Addendum No. 1

RE: Contract ID: C201634
WBS# 39692
Lee County
SR-1579 From SR-1535 To SR-1538.

September 19, 2006 Letting

PROJECT REFERENCE NO. <b>39692</b>	SHEET NO. <b>UC-2</b>
DESIGNED BY: VM	
DRAWN BY: VM	
CHECKED BY: RGW	
APPROVED BY: RGW	
REVISED:	
NORTH CAROLINA DEPARTMENT OF TRANSPORTATION PROJECT SERVICES UNIT PHONE: (919) 250-4128 FAX: (919) 250-4119	
UTILITY CONSTRUCTION PLANS ONLY

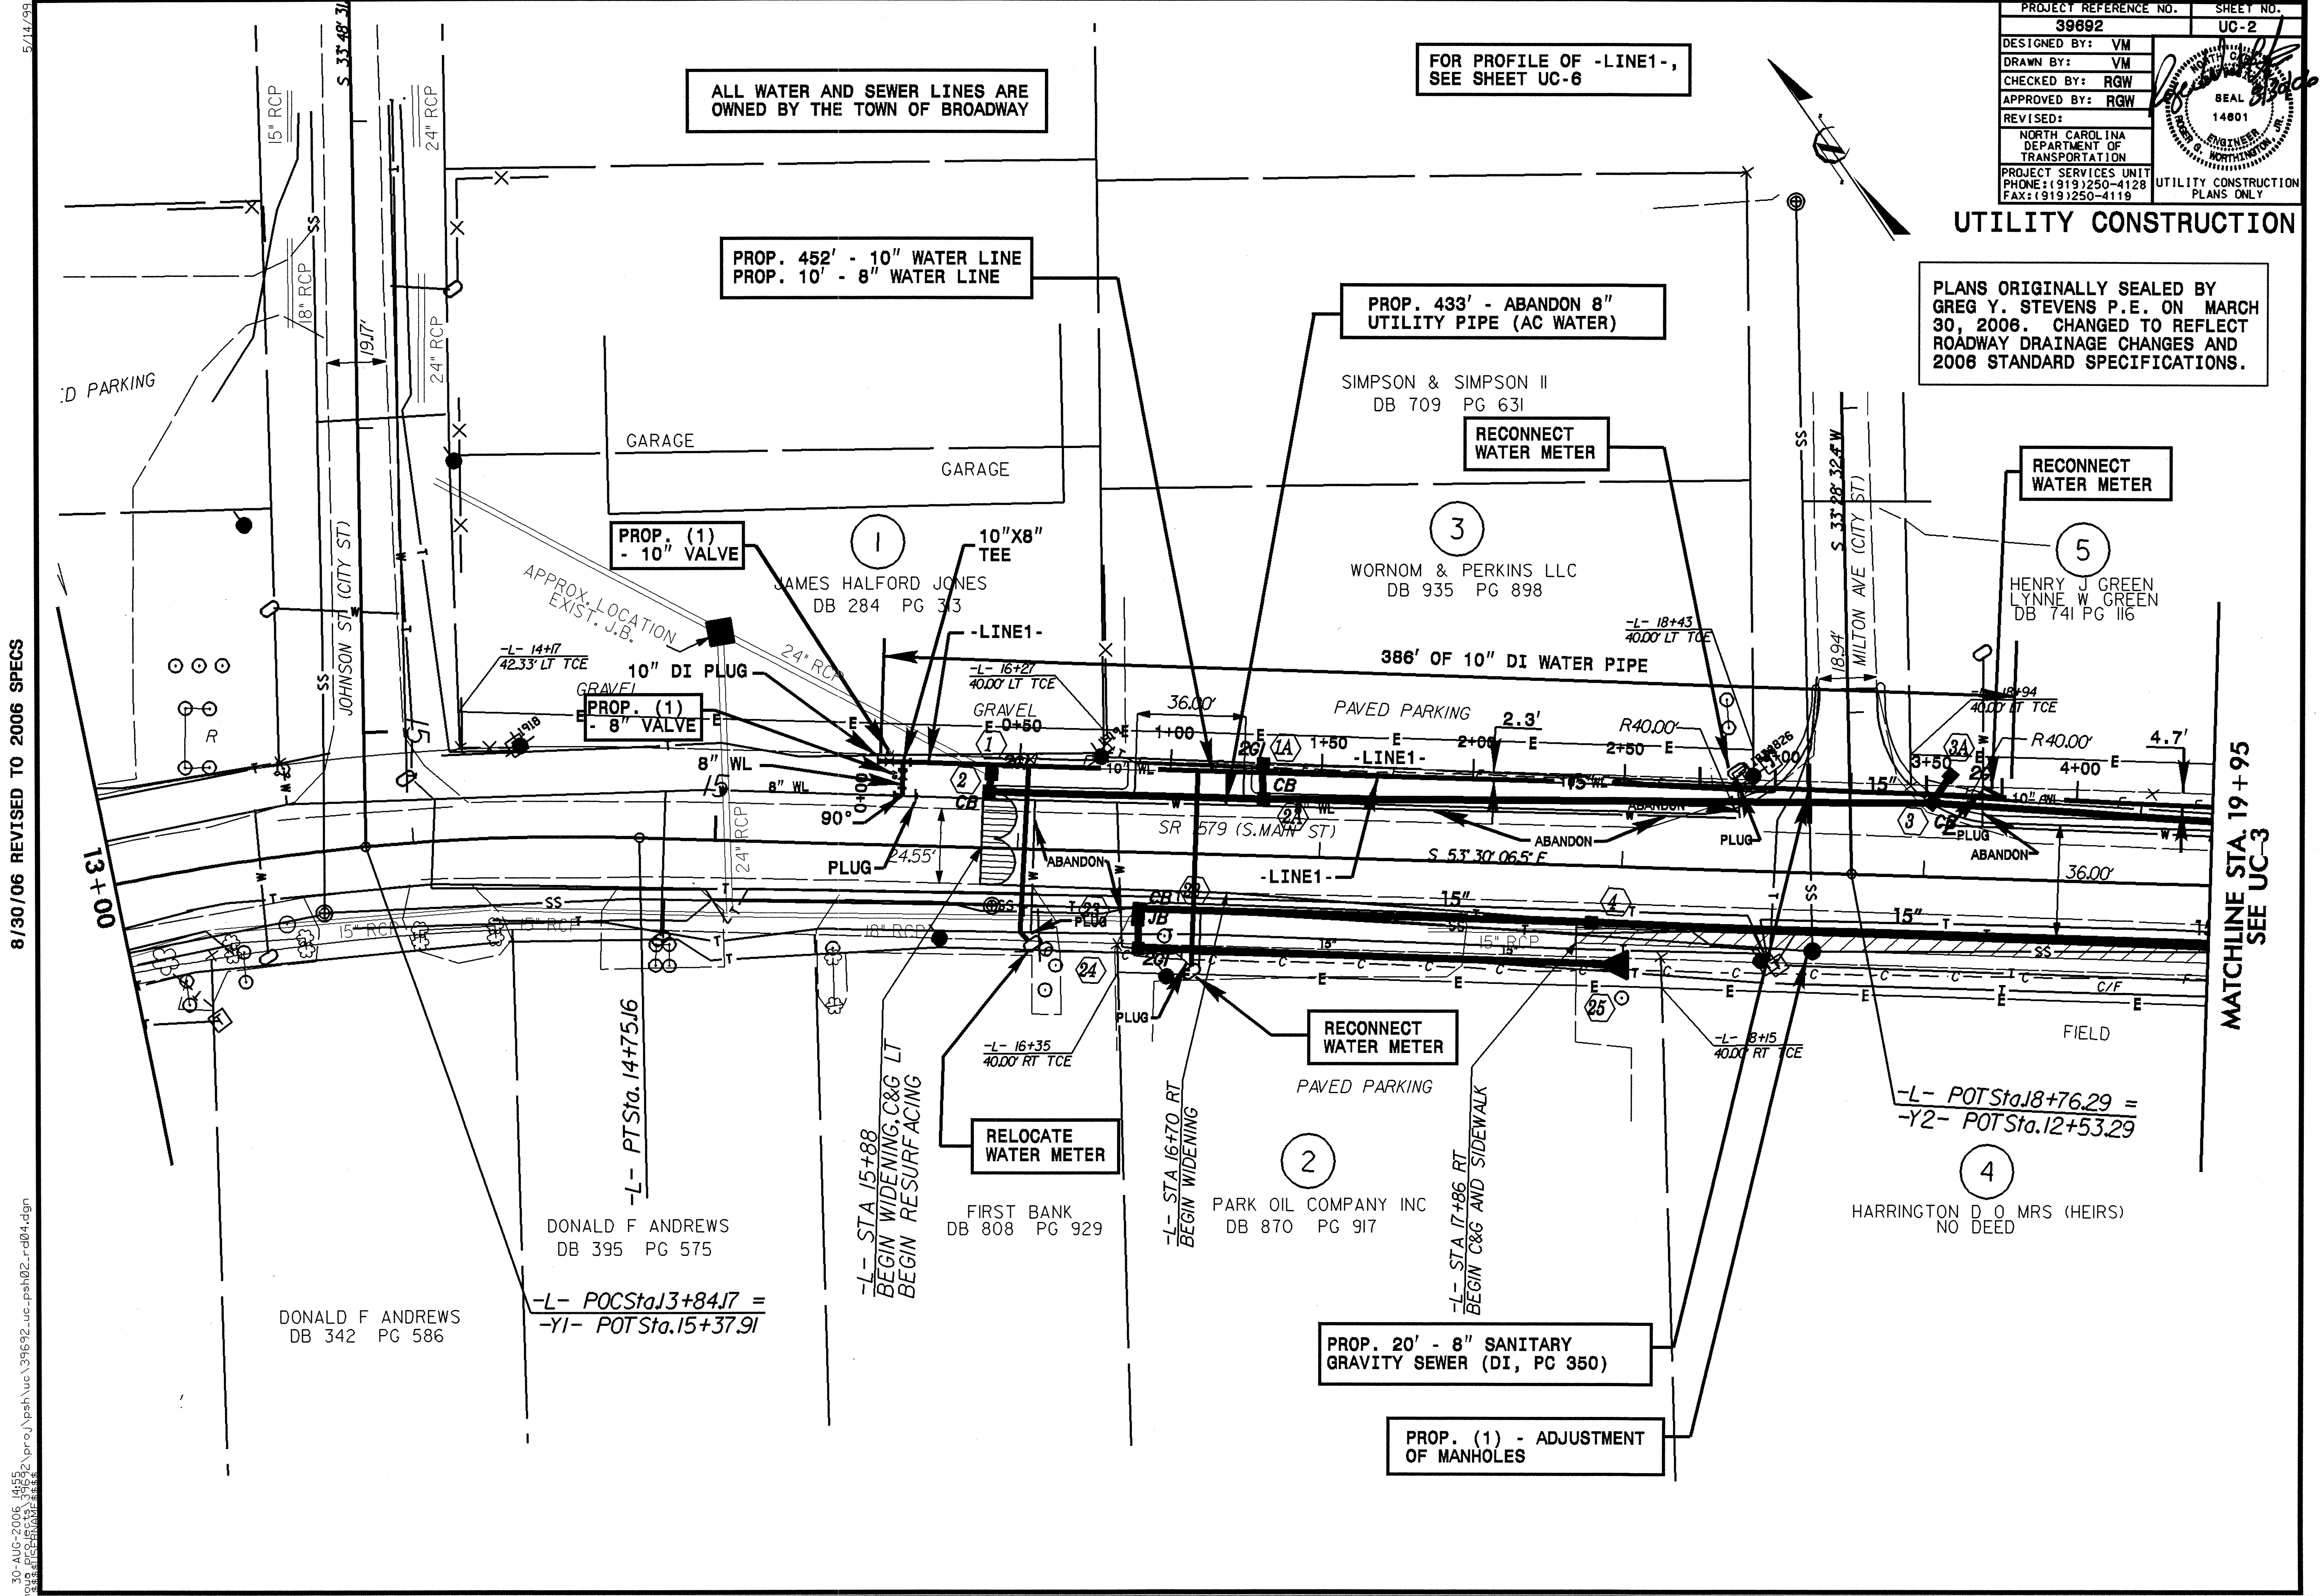
Sheet Nos. UC-1 thru UC-7 have been revised to correct various plan notes and to update to 2006 Standard Specifications. Please void Sheet Nos. UC-1 thru UC-7 in your plans and staple the revised Sheet Nos. UC-1 thru UC-7 thereto.
